Planning Application Ref: BR/258/21/T

Location: 252 Hawthorn Road, Bognor Regis, PO21 2UP

Description of works: Crown reduction of 1no. *Quercus robur* (English Oak) to height 18m and spread 8m

Drawing	Scale
SITE PLAN	1:500 @A3

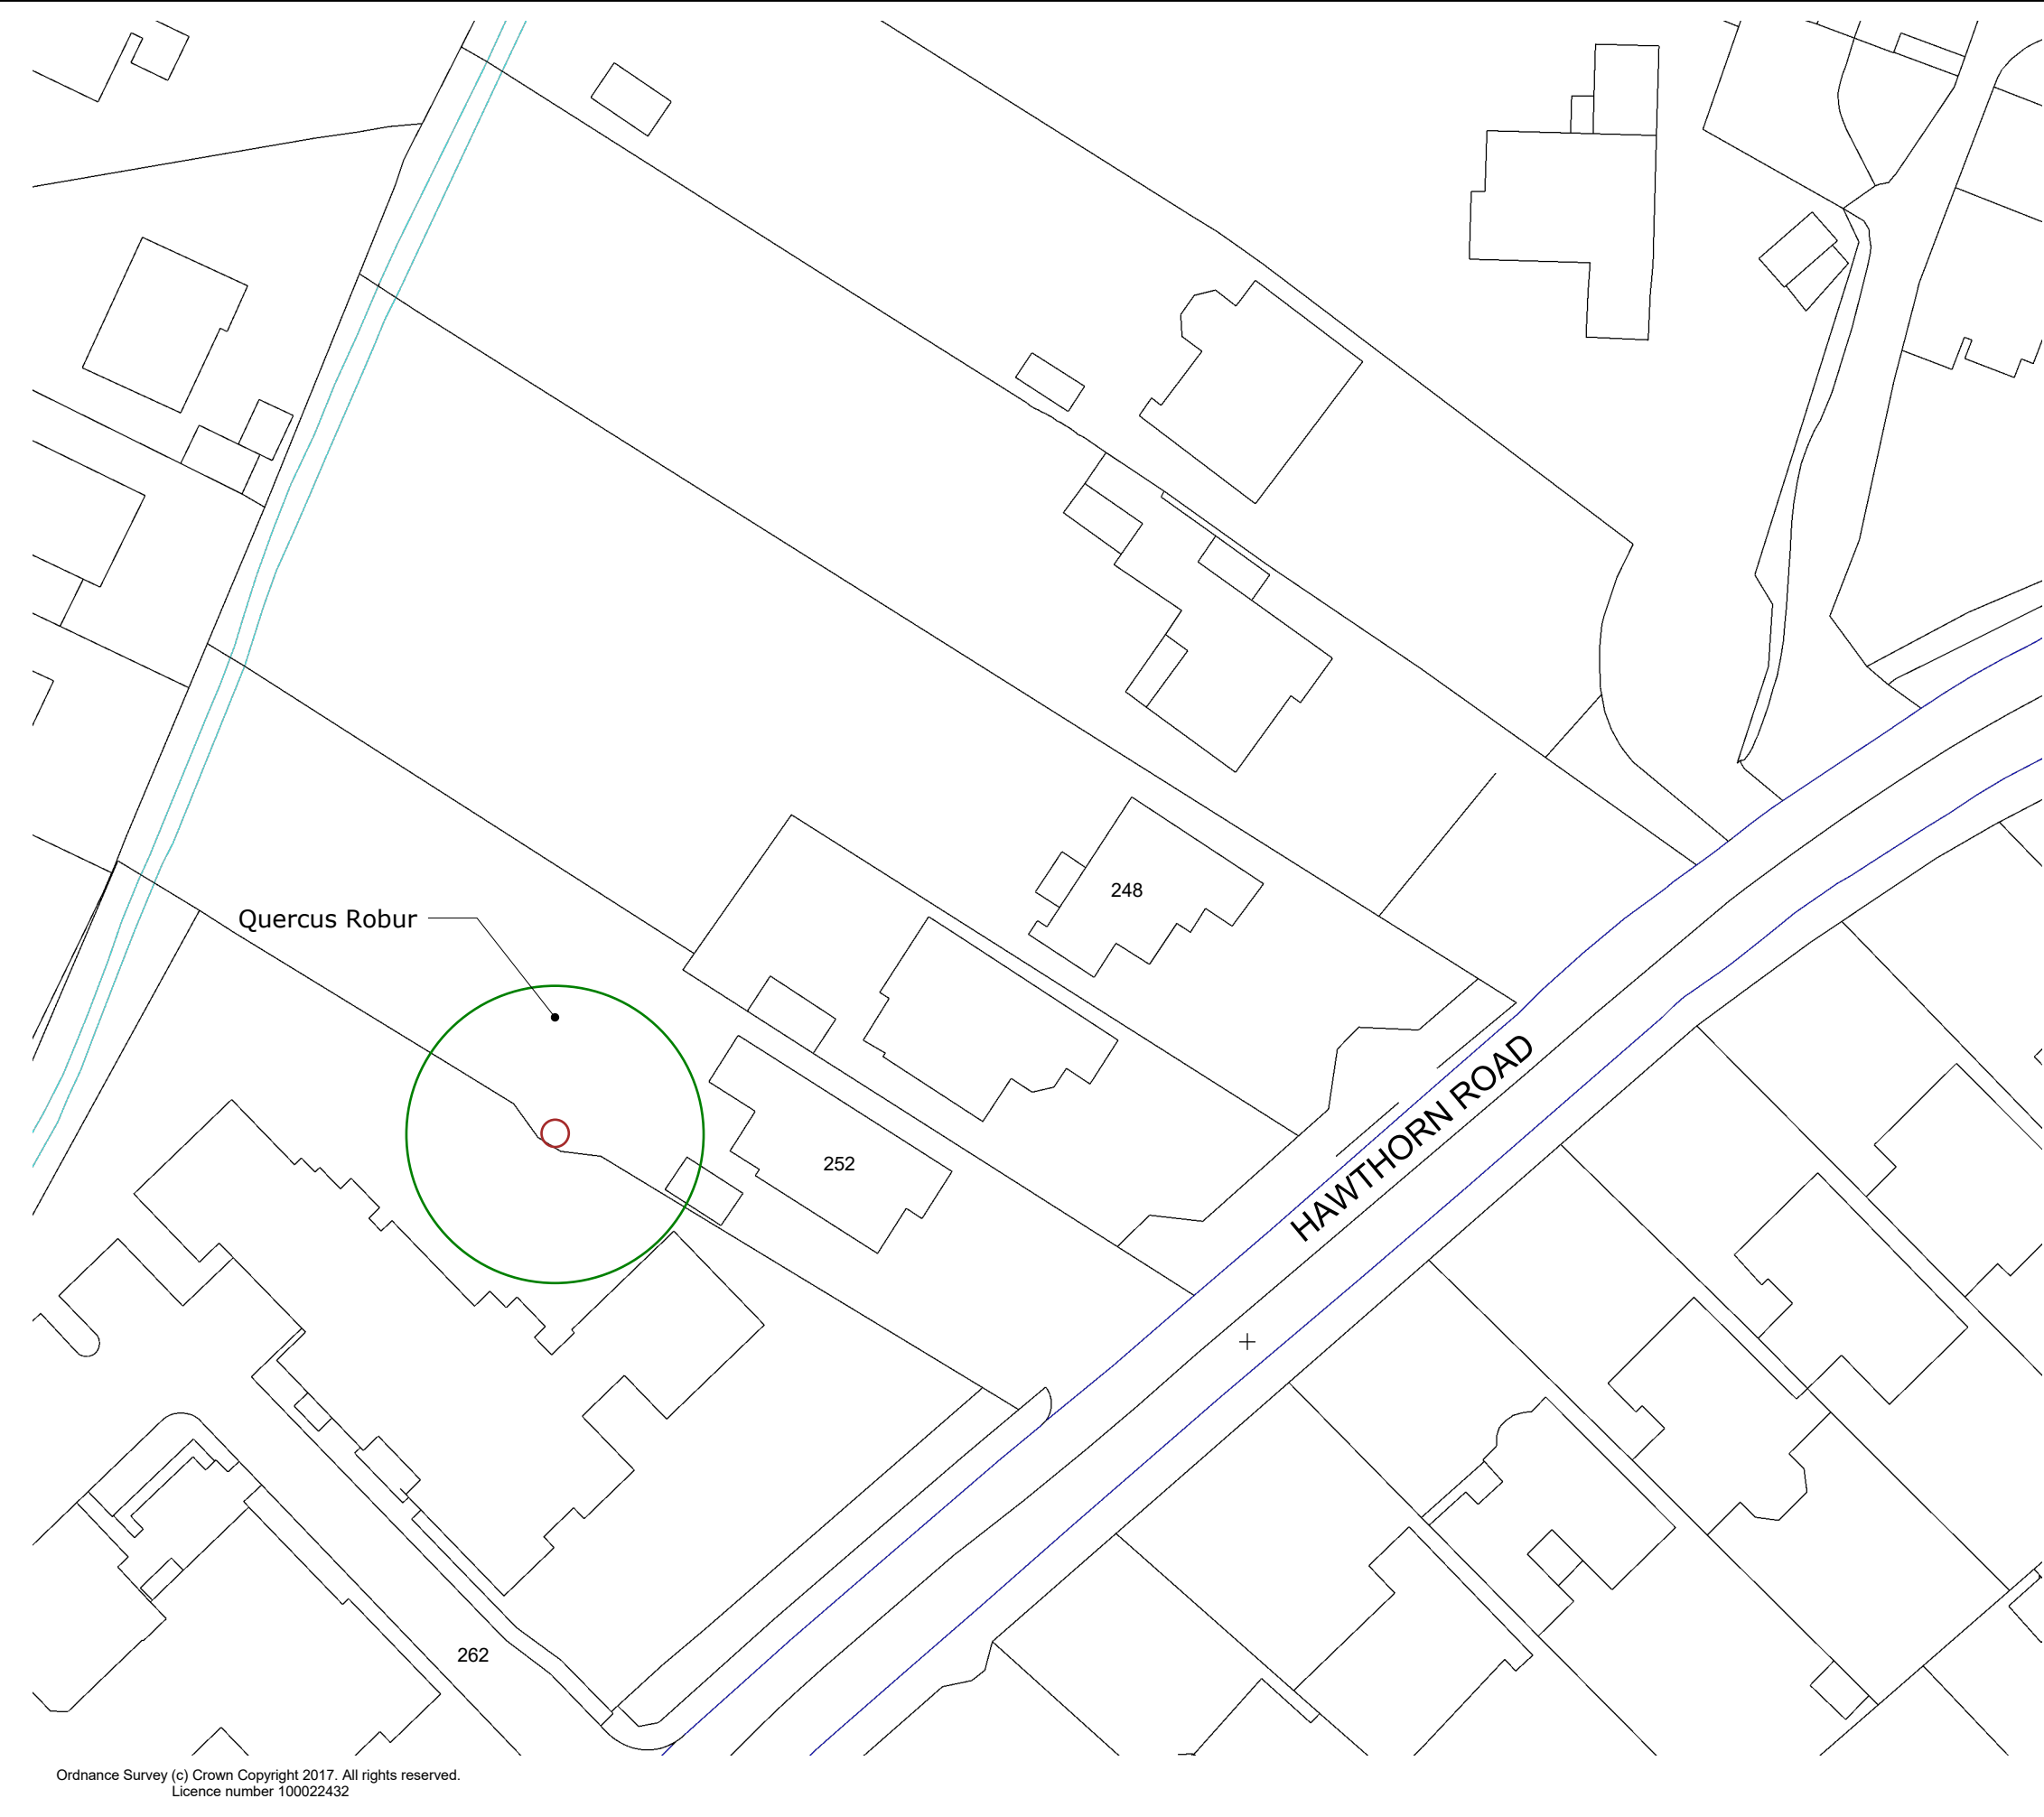
- It grows so close to a rear garden boundary that it dominates the outlook from the back of the owner's property as well for some apartments in neighbouring Pagham Court – a relatively recent development in the history of this long-established tree.

- This application seeks to initiate whole crown reduction that would incur a volume loss of approximately 40%.
- Overhead and lateral clearance of branches above and from affected properties appear adequate but there is scope for some light pruning to improve conditions and provide long-term clearance.

- This tree will always be a dominant feature for those properties nearby but could remain in harmony with its surroundings under careful management.
- The tree is a significant feature in the local landscape and appears to be in adequately sound and healthy condition. The proposal to reduce both the height and lateral spread on all aspects (the correct interpretation of *crown reduction*) by such an extent may result in harm to the health and vitality of the tree with large pruning wounds being formed as well as undermining its visual amenity value and impact in the landscape.

- *Crown lift to provide maximum of 3metres overhead clearance from ground level, on all aspects.*
- *Reduce/remove branches as necessary to provide a maximum of 2metres clearance from all adjacent dwellings and outbuildings.*
